A46 Coventry Junctions (Walsgrave) Scheme number: TR010066

5.2 Consultation Report Annexes **Annex O: Tables evidencing regard had to section 51 advice**

CONSULTATION REPORT ANNEXES
Annex O: Tables evidencing regard had to section 51 advice

Section 51 advice regarding draft application documents submitted by National Highways

NOTES:

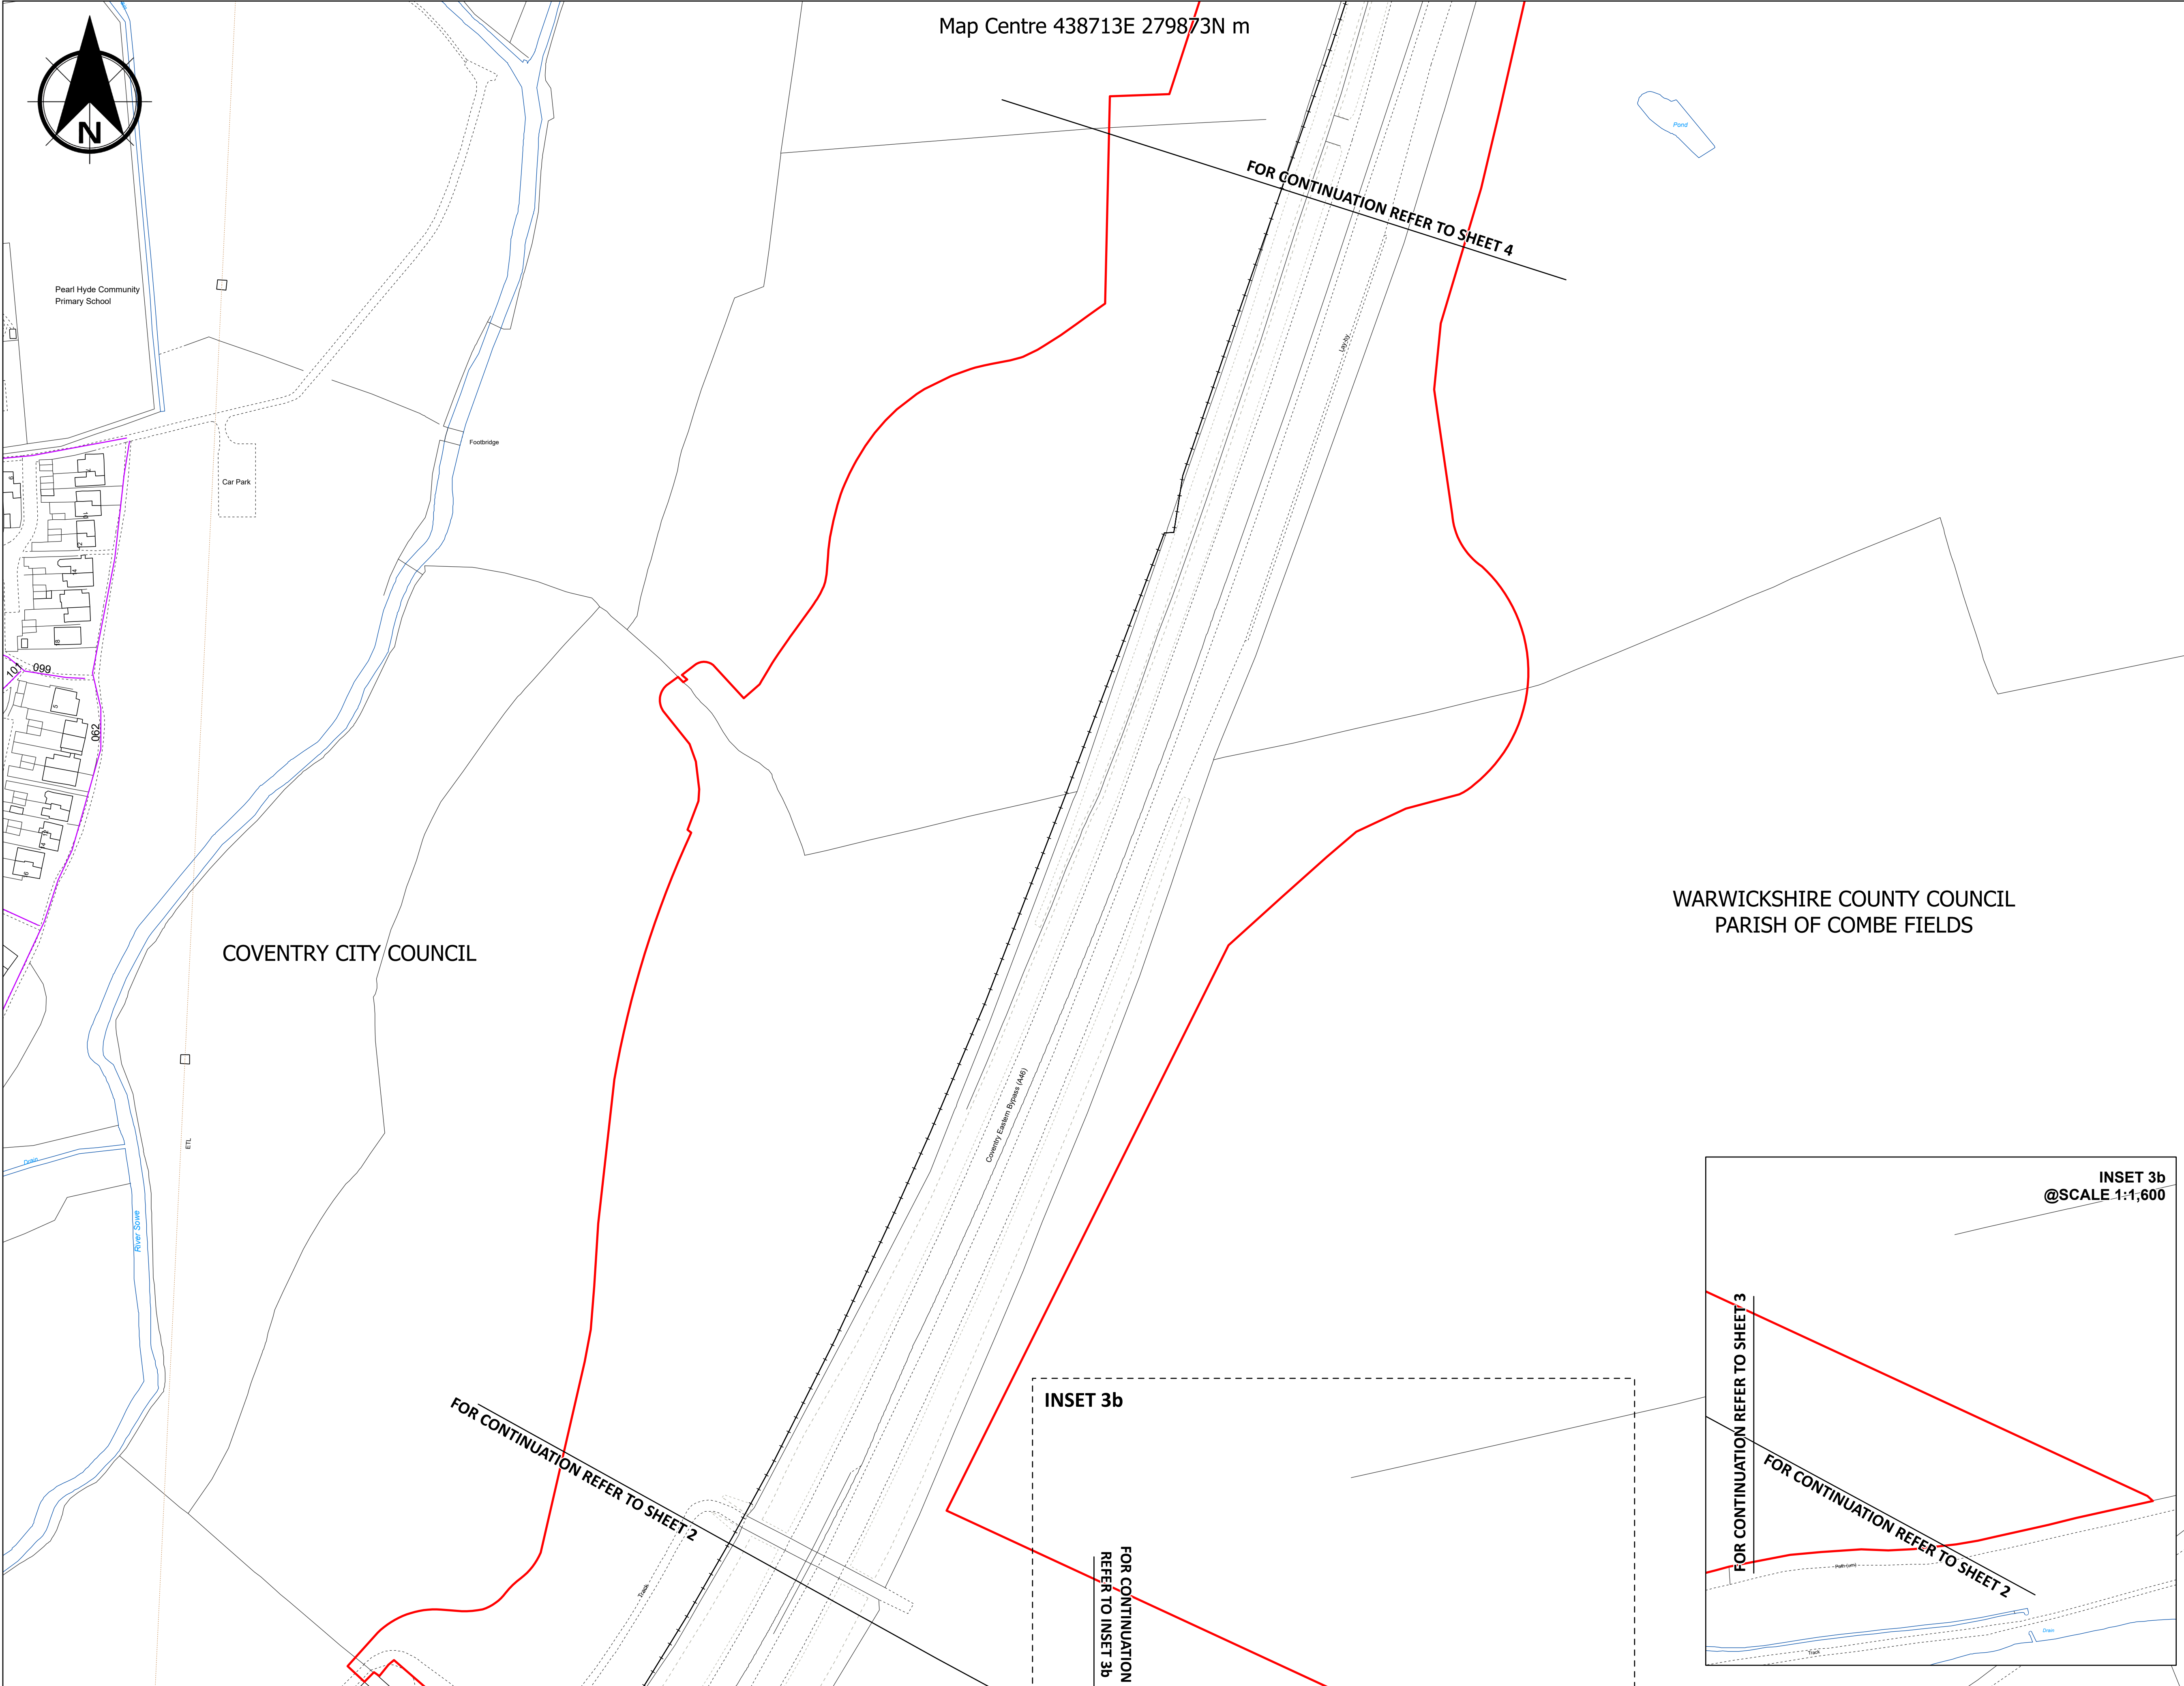
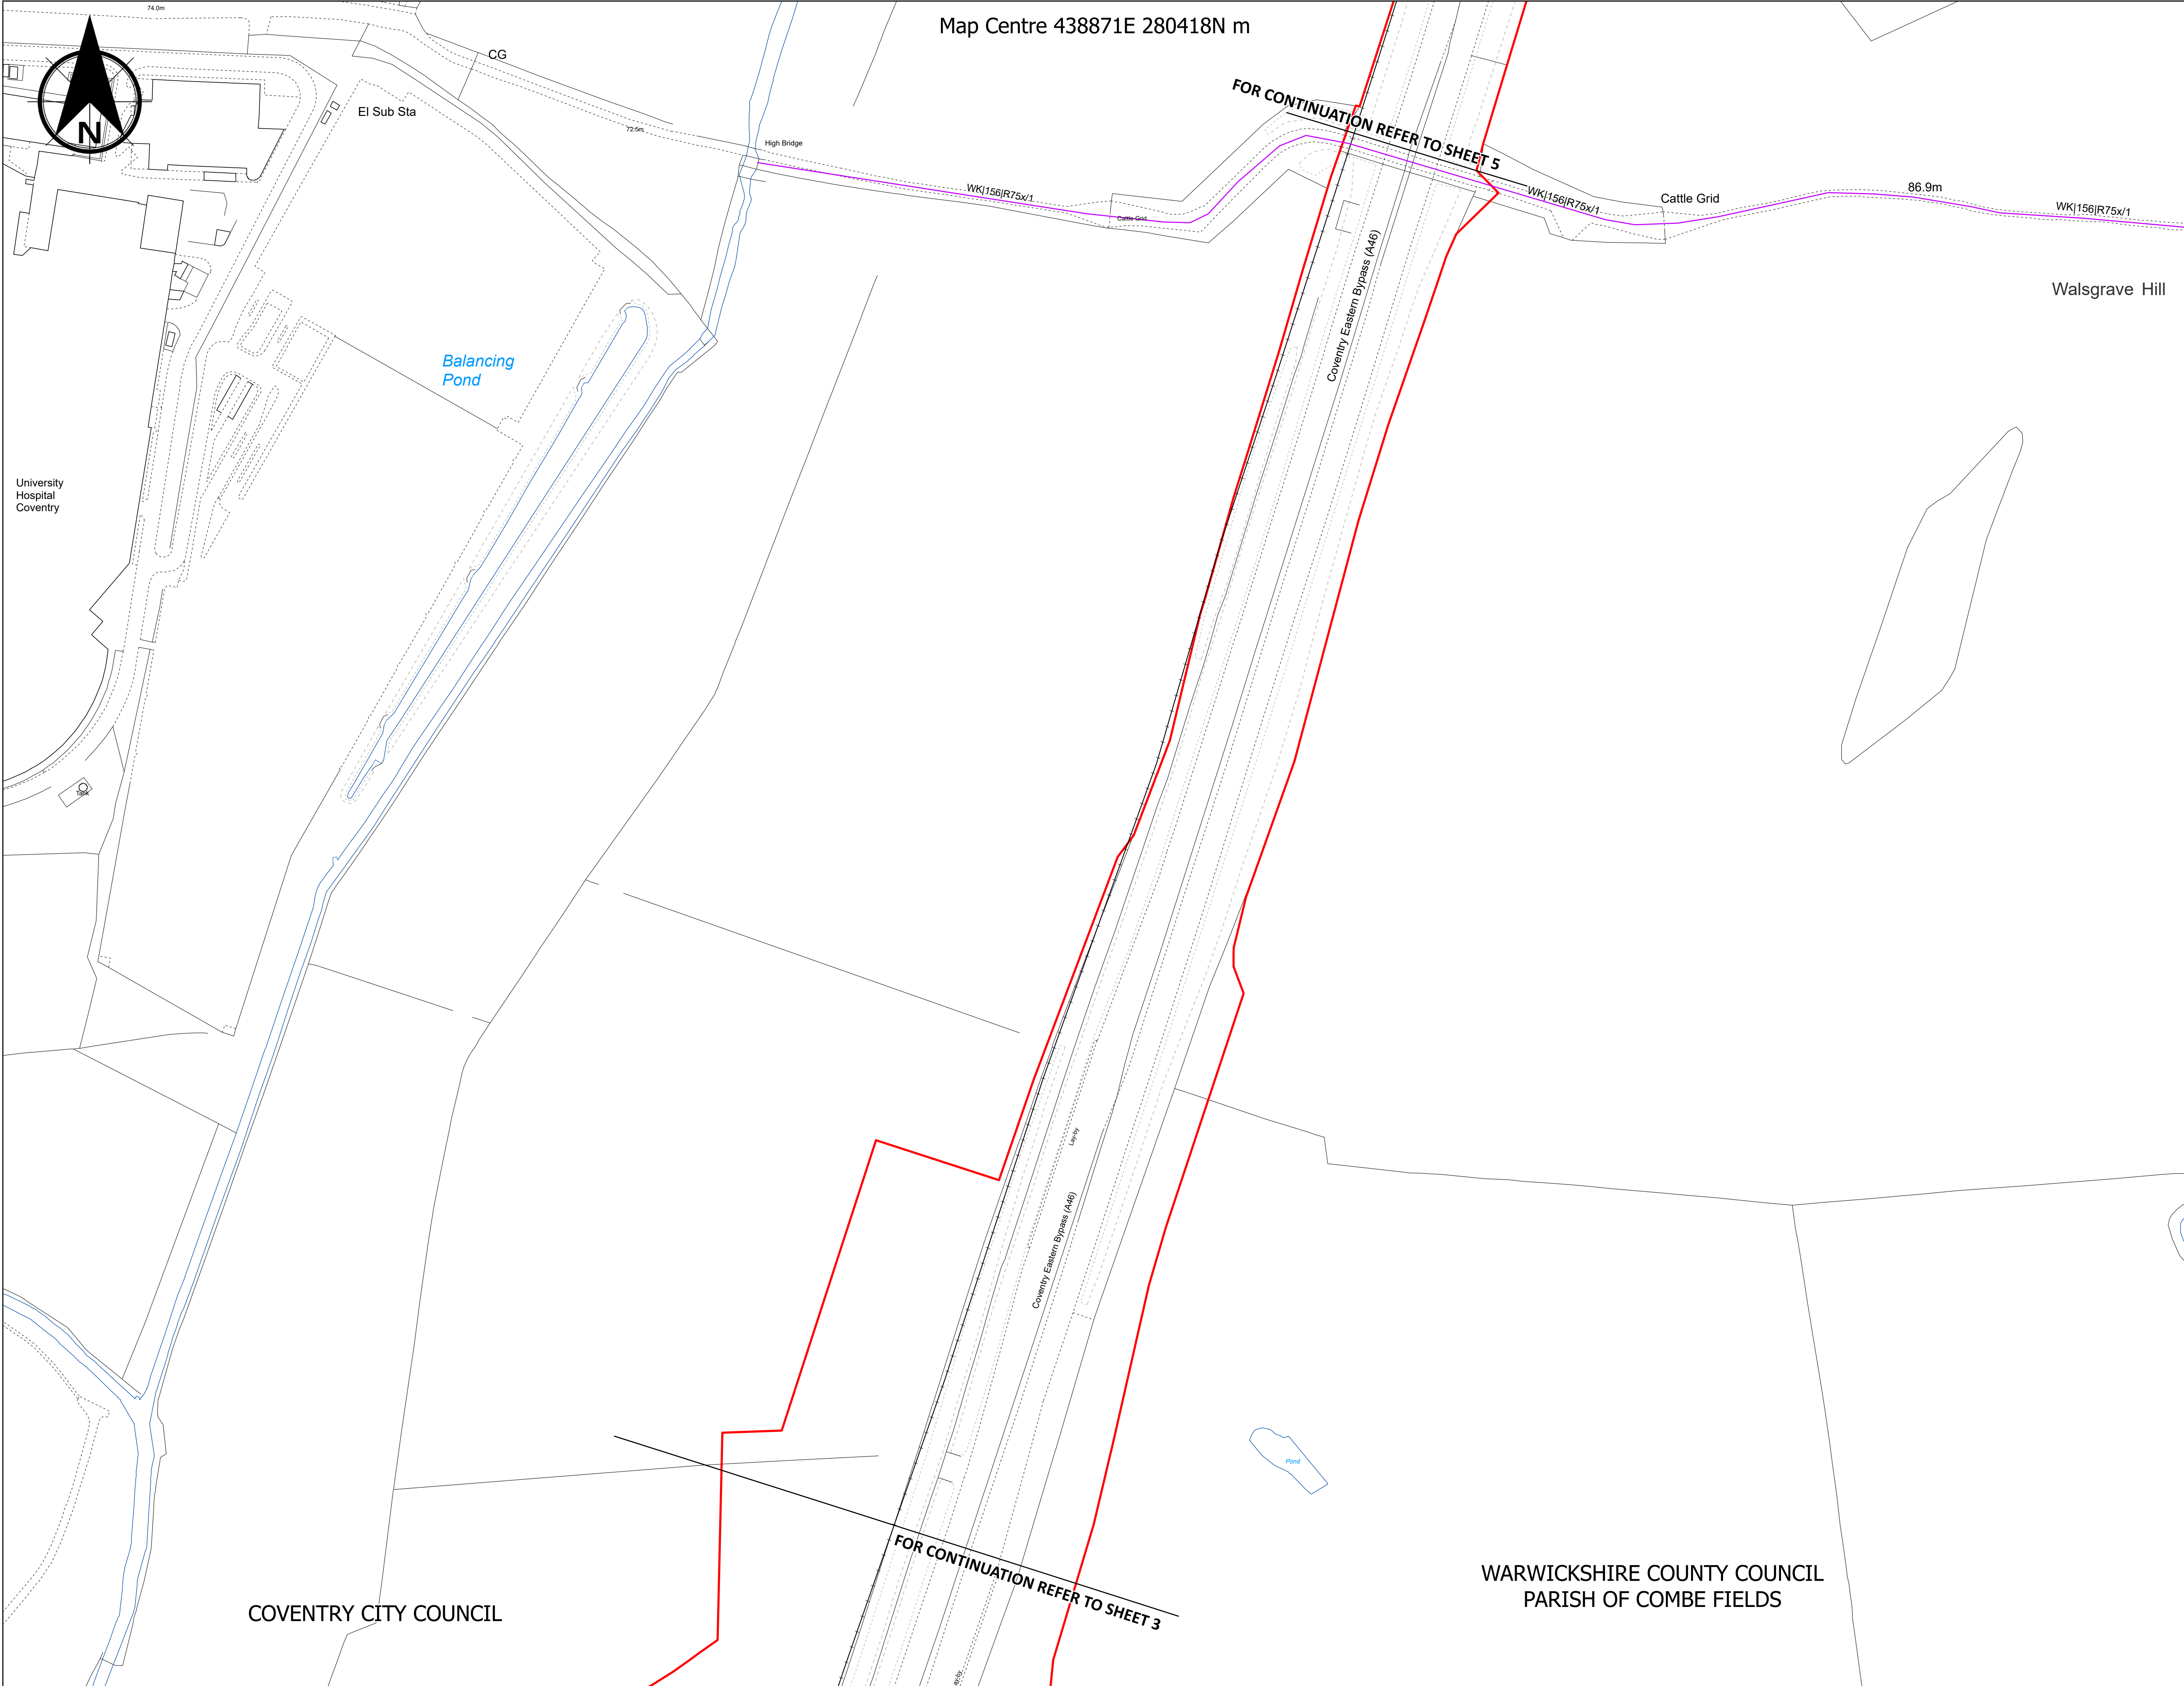
Sheet 3 of 5	<i>As above – ensure there are clear cut lines across all plan sheets as per APFP Reg 5(2)(i).</i>	The Applicant has reviewed and updated the Land Plans (TR010066/APP/2.2) as required to ensure there are clear cut lines across all plan sheets as per APFP Reg 5(2)(i).
		<i>The Applicant should consider having lines between the cut lines for the insets and the zoomed in scale boxes to show easily where they are.</i>	The Applicant has amended the Land Plans (TR010066/APP/2.2) so that the lines between the cut lines for the insets and the zoomed in scale boxes show easily where they are.
		<i>Sheets 2a and 3a are just titled 'Sheet 2, Inset 2D' and 'Sheet 2, Inset 3C' and should be titled 'Sheet 2A....' and 'Sheet 3A...'</i>	The Applicant has amended the titles of the sheets on the Land Plans (TR010066/APP/2.2) as suggested.

Ref No.	Paragraph/ Section	Comment or question (The Planning Inspectorate)	Applicant's regard to section 51 advice
	Sheet 1 of 5	<i>Please identify in the key the small triangle to the right of Plot 1/4 which is edged red but not coloured or numbered.</i>	This is an error and should not have been included, the Land Plans (TR010066/APP/2.2) Sheet 1 has been amended to remove this.

Sheet 3 of 5	<i>Ensure in '3A' all plots are labelled.</i>	This has been reviewed and all the plots are now labelled in the Land Plans (TR010066/APP/2.2).

Sheet 2 of 5	<i>Ensure all plot numbers are in the cut lines as well as the zoomed in scale box.</i>	All plots are clearly labelled on the Land Plans (TR010066/APP/2.2).
